**Case Officer:** Linda Griffiths

**Applicant:** L&Q Estates

**Proposal:** Discharge of condition 41 (right of way alternative route) of  
14/01932/OUT

TITLE  
**ROW Route**

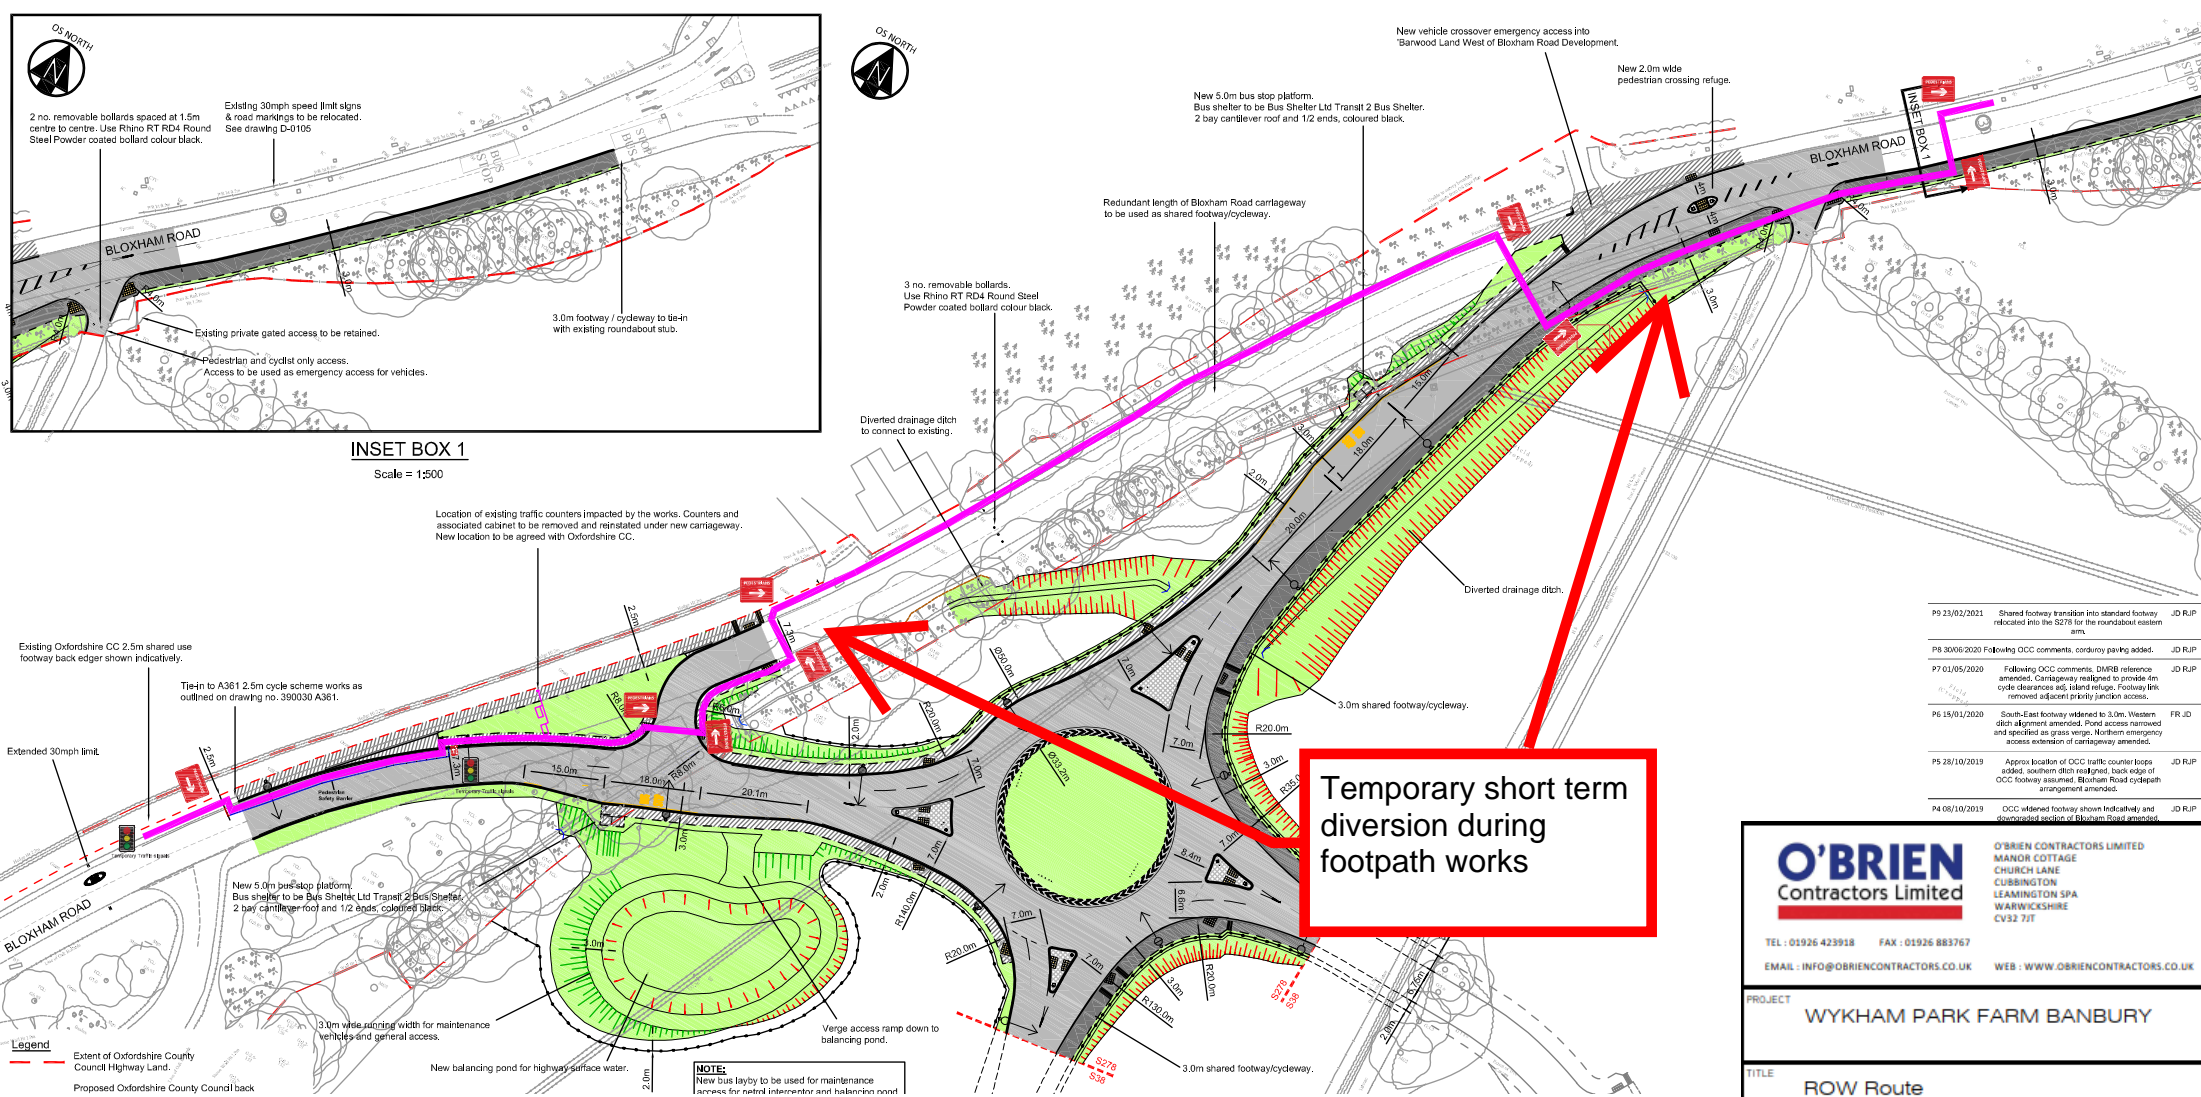
- 6.3. Currently, FP/49 runs along the western side of the development close to Bloxham Road and needs to be diverted in conjunction with the construction of the new access into the development. A temporary diversion which will take pedestrians along the pavement on Bloxham Road is necessary from a pedestrian safety point of view. The permanent diversion diverts the footpath through the open space and around an attenuation basin to a safer crossing point on the new roundabout.

- 6.4. The proposals have been assessed by OCC as both highway and public rights of way authority. Initially OCC raised an objection on the grounds that the details of the proposed diversion route were insufficient and requested details of the crossing facilities of the A361 and access/spine roads, cross-sections, surfaces, furniture and lighting. It was considered that the alternative route could not be deemed acceptable until those aspects had all been clarified and found to be acceptable.

- 6.5. Following the submission of revised documentation and information OCC removed their objection advising that the condition can be discharged as the applicant commits to protecting the existing temporarily diverted public rights of way and has set out a temporary diversion route for the footpath 49. The undertaking to improve/firm the surface of the temporary route is noted and should be done before TTRO comes into effect. The temporary route needs ongoing maintenance (strimming/mowing/fence checking) throughout the period of the temporary diversion. For the permanent diversion, OCC will want to see details of proposed route, width and structures in order to reach agreement.
